From: Rachel Alderson
Sent: 15 August 2018 15:32
To: Planning.Responses
Cc: Michael Eastham
Subject: FW: Planning Consultation on: A/81/18/RES

2018
Site Address: Quiet Waters Roundstone Lane Angmering BN16
4AX
Grid Reference: 507454 103377
Description of Works: Approval of reserved matters following outline consent A/132/17/OUT for appearance, landscaping, layout & scale for demolition of existing dwelling & the erection of 30 No. dwellings.

Drawing Title:
Proposed Affordable housing

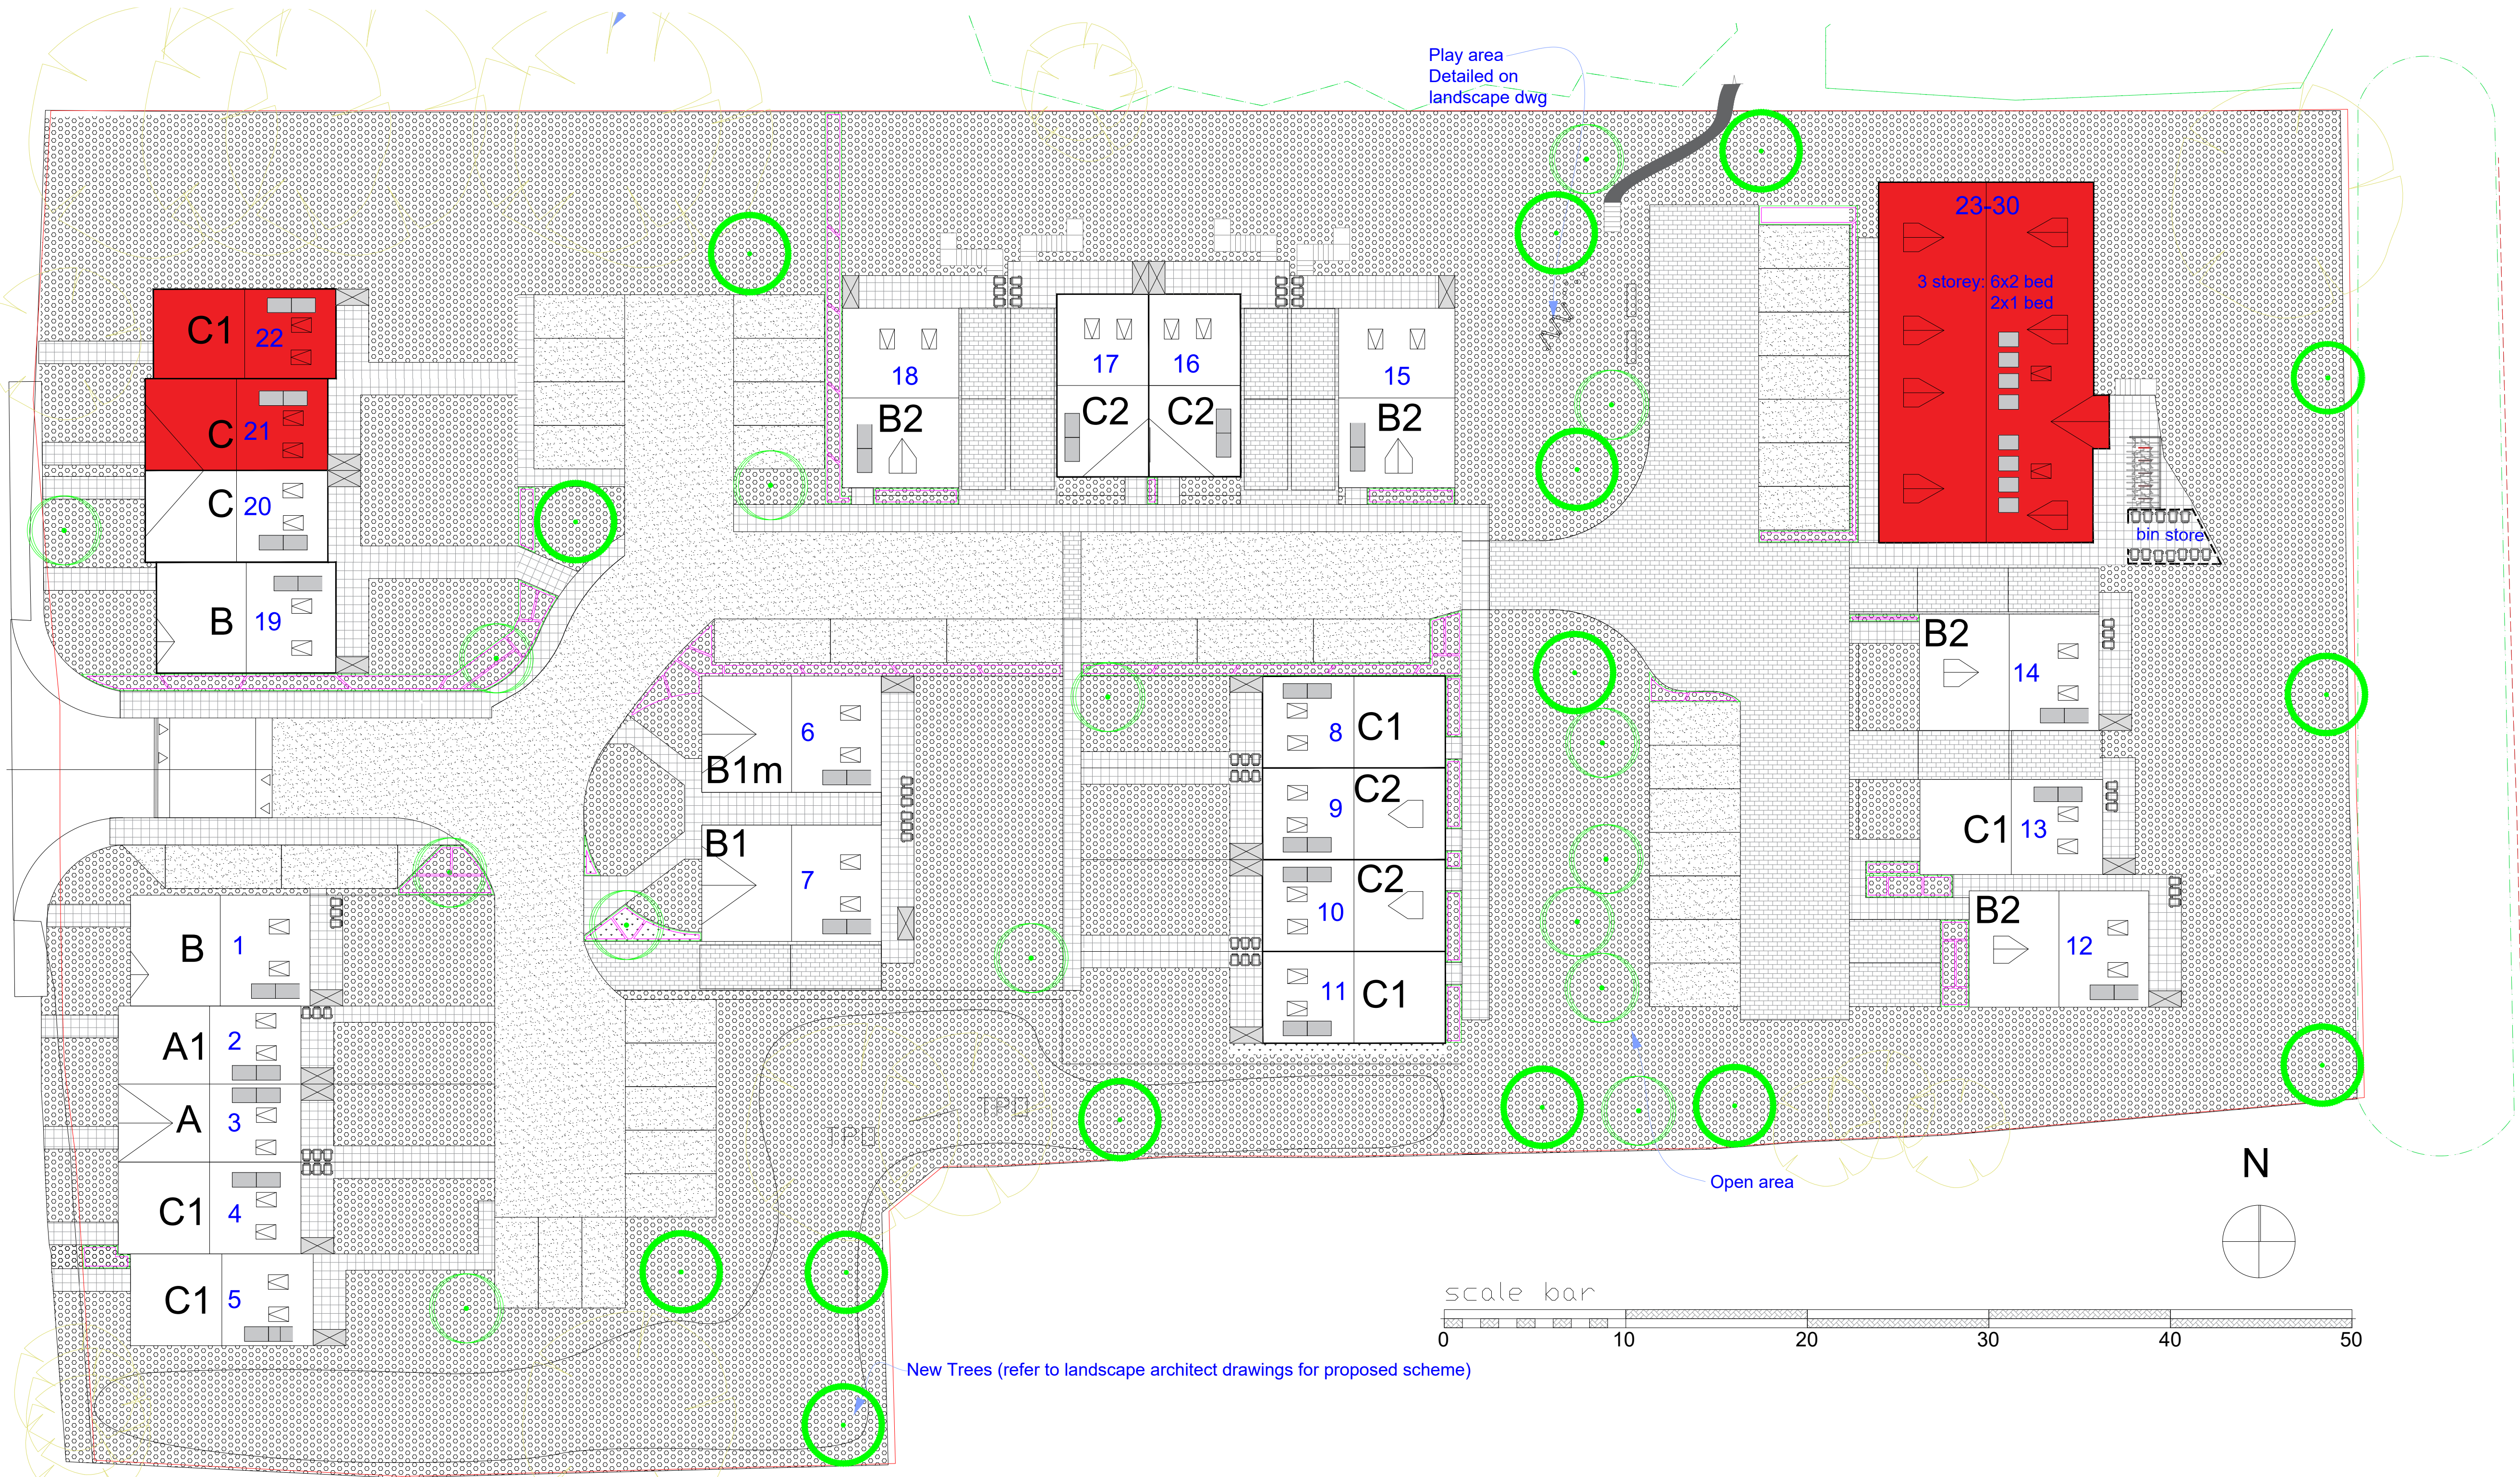
The submitted plans have not taken on board previous comments made in relation to the allocation of open space. In this application the open space has been located behind or to the side of a number of properties and to the rear of a parking area. It is therefore hidden away and will not benefit from natural surveillance. The sloping gradient of this part of the site will restrict access to the open space and does not meet the required criteria of being in a usable form. A better location for the open space would be on the north of the development site which would provide links and connectivity with open space on the adjacent neighbouring development.

In conclusion I would not recommend the submitted plan for approval.
